Our ref: HA/2021/122941/01-L01
Your ref: FP/248/20/PL
Date: 23 February 2021

REVISED DETAILS RELEVANT TO THE SPORT PITCH & CHANGING FACILITIES BUILDING (PREVIOUSLY APPROVED UNDER Y/38/09/). THIS SITE ALSO LIES WITHIN THE PARISH OF YAPTON & IS IN CIL ZONE 4 (ZERO RATED) AS OTHER DEVELOPMENT

LAND NORTH OF FELPHAM

Drawing Title:
CHANGING FACILITIES BUILDING

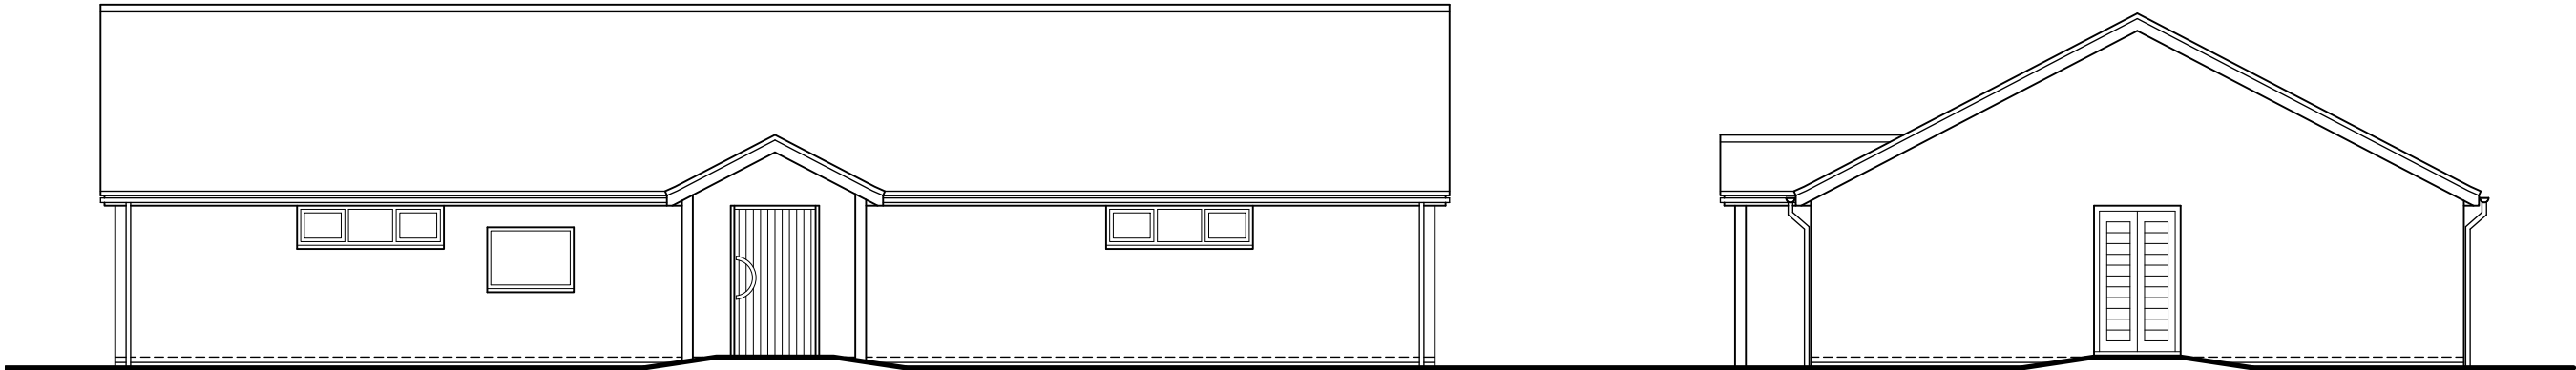
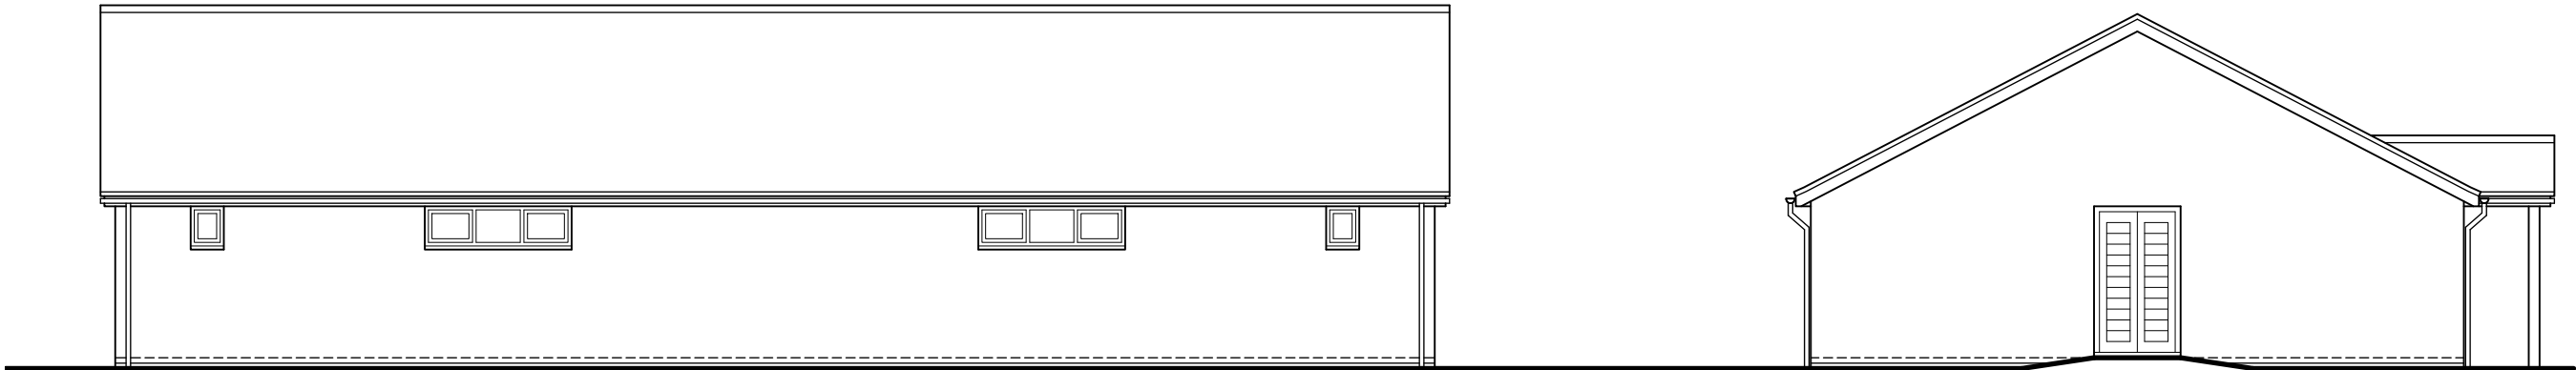
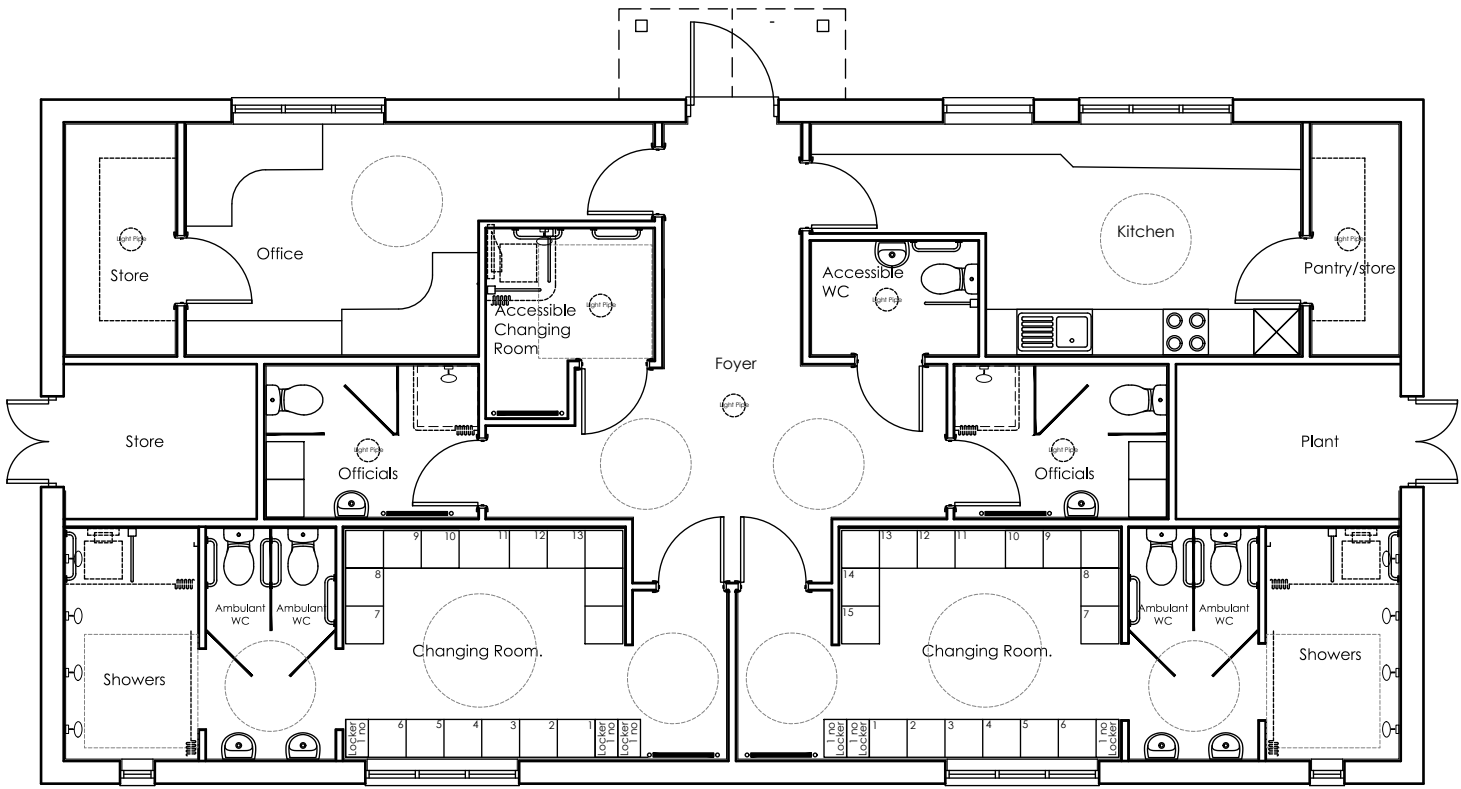
The development shall be carried out in accordance with the submitted flood risk assessment submitted by MJA Consultants and the following mitigation measures it details:

- Finished floor levels of the changing rooms shall be set 300mm above the surrounding ground levels.
